**Transport
for NSW**

Proposed Modification to Student Accommodation Building W2 at the Darling Drive Plot, Sydney International Convention, Exhibition and Entertainment Precinct (SSD 6010 MOD 1) - Notice of Exhibition

CD15/21632

Drawing Title
ROOF TERRACE

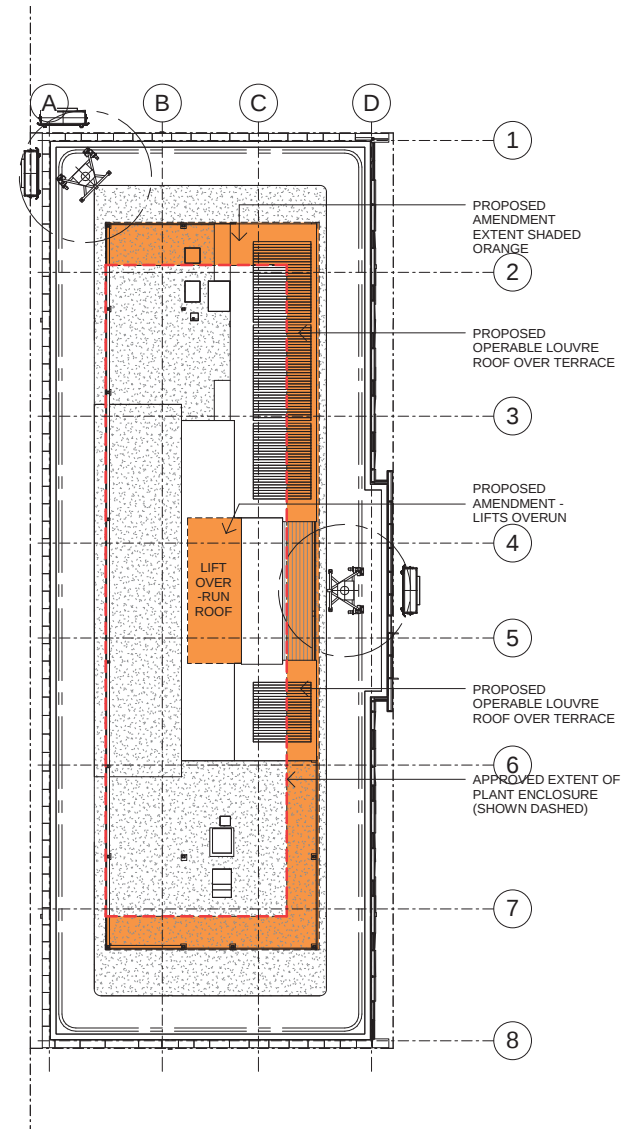
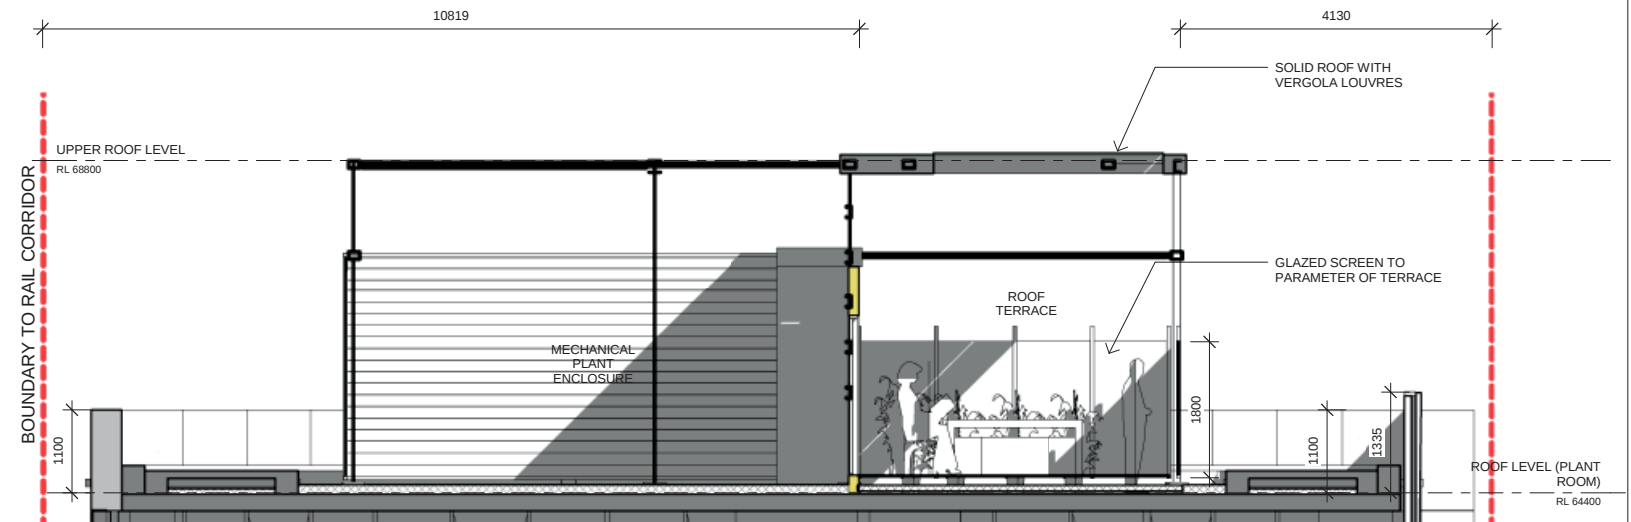
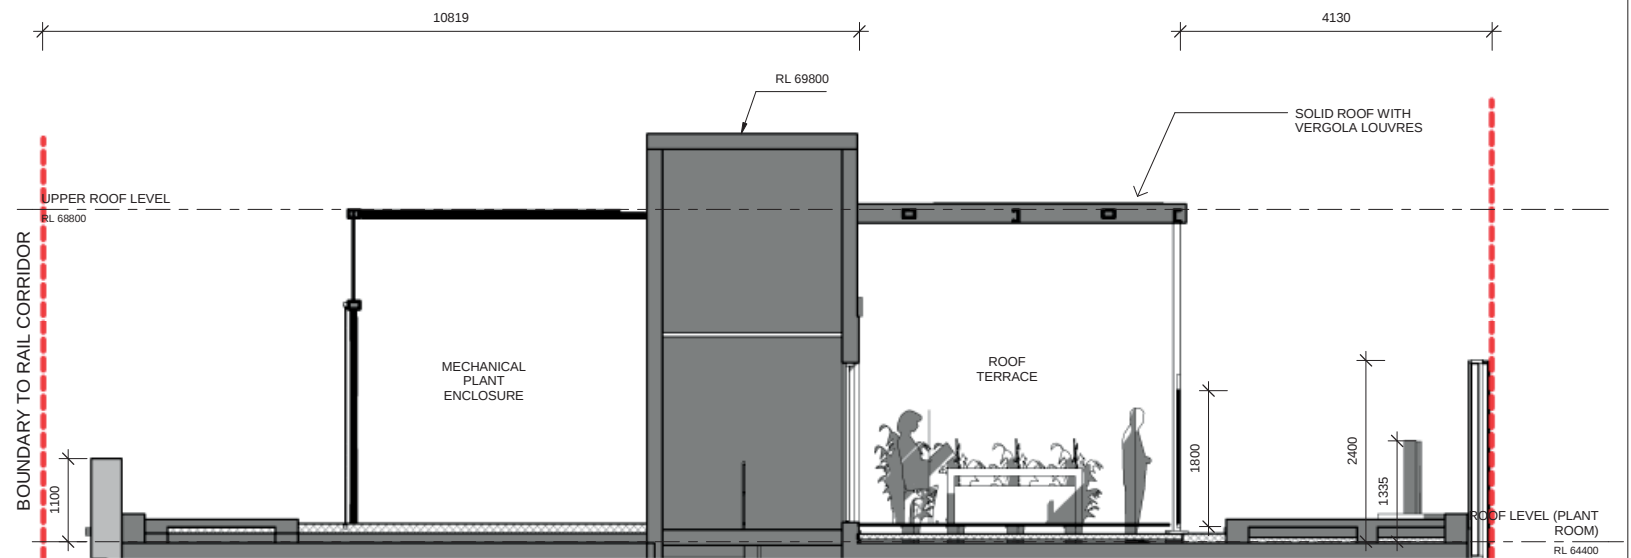
TfNSW has reviewed the submitted information and has no concerns with the proposed modification on the basis that:

- The proposed communal rooftop terrace is on the eastern side of the W2 Student Accommodation building; and
- Measures will be in place to prevent resident access to the western side (light rail side) of the building in order to prevent residents throwing objects over the side and into the Light Rail corridor.
